Rezoning Transportation Analysis

Petition Number: 2023-069

Date	Description
10-26-23	First Review (NK)

**RZP-2023-069
 REZONING**

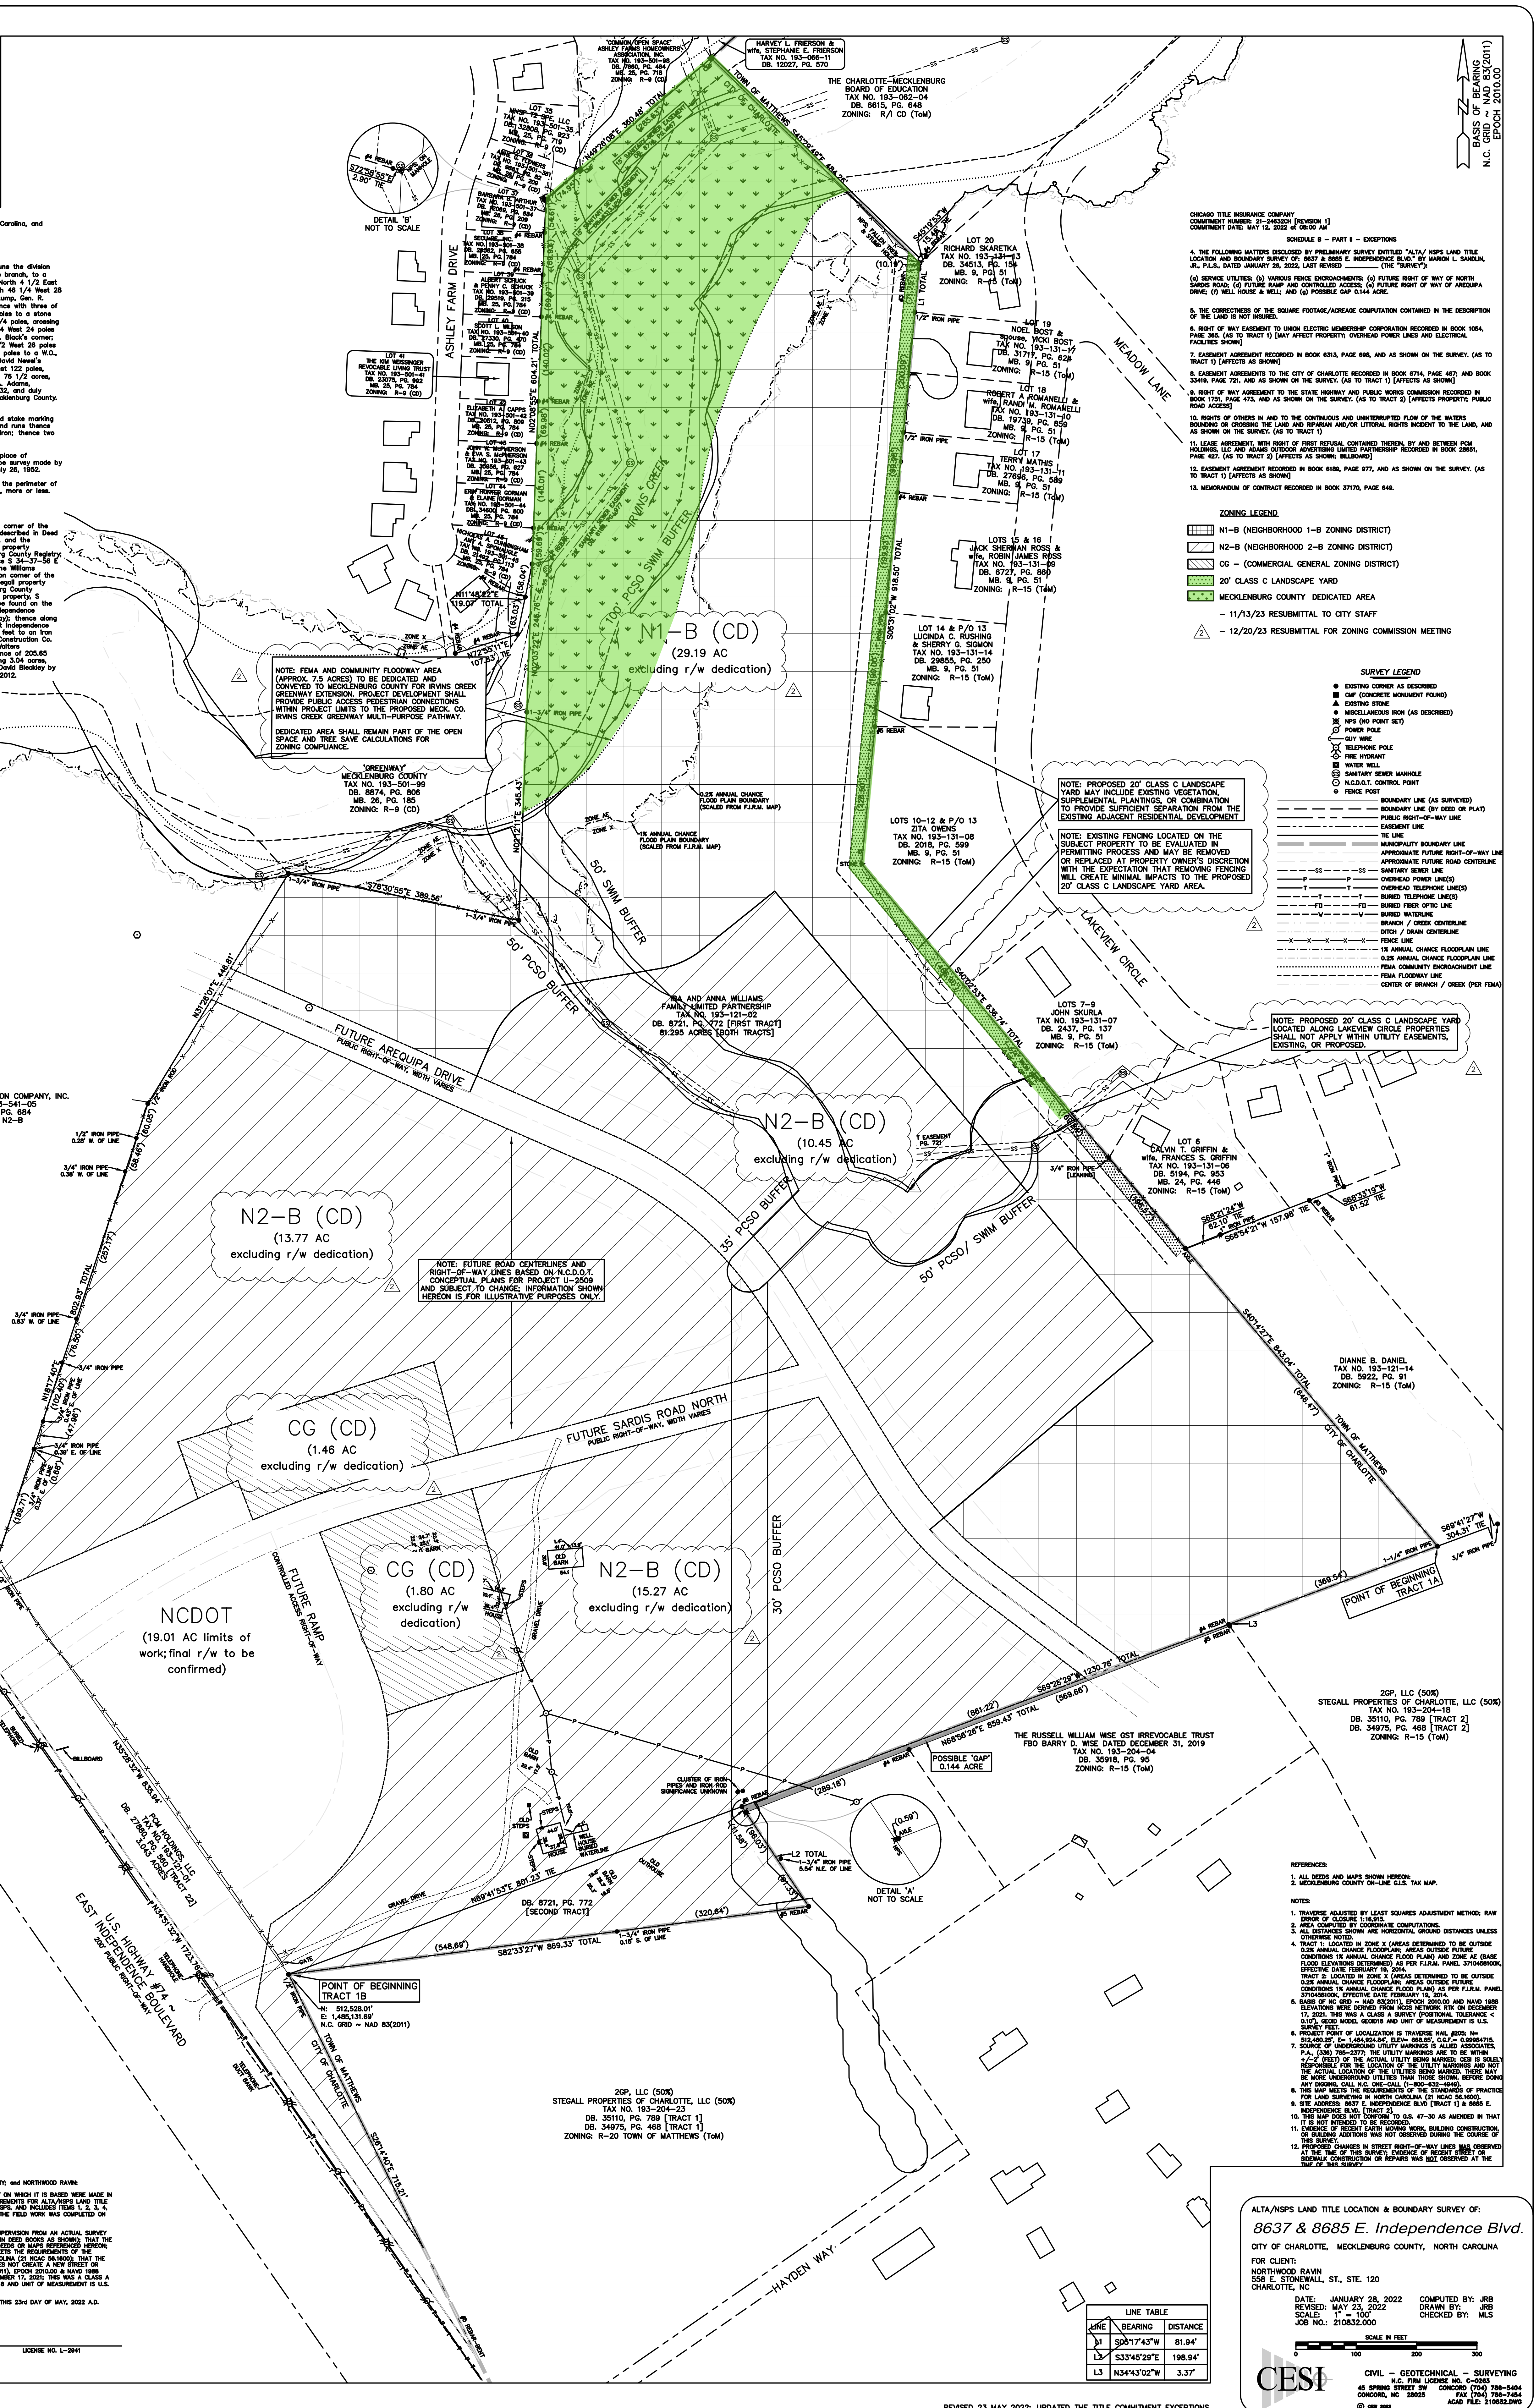
Label and dimension the curb and gutter from the centerline for each road on the site plan.

- 3. Revise site plan and conditional note(s) to commit to dedicate 54' right-of-way from the road centerline for Sardis Road North. The site plan shall label and dimension the right-of-way from the road centerline.

Revise site plan and conditional note(s) to commit to dedicate 40' right-of-way from the road centerline for Arequipa Drive. The site plan shall label and dimension the right-of-way from the road centerline.

4. Revise site plan and conditional note(s) to commit to construct bicycle facilities by locating the curb and gutter 38' from the center line along Sardis Road North.

6. Revise site plan to include cross sections, road classification, and width for proposed public roads.
7. Revise site plan to commit to extending Sardis Road North to edge of property line.

8. Revise site plan and conditional note(s) to commit to installing 6' sidewalk and an 8' planting strip along Sardis Road North and Arequipa Drive.
9. Revise site plan to show any other proposed private streets and provide location of all future buildings.
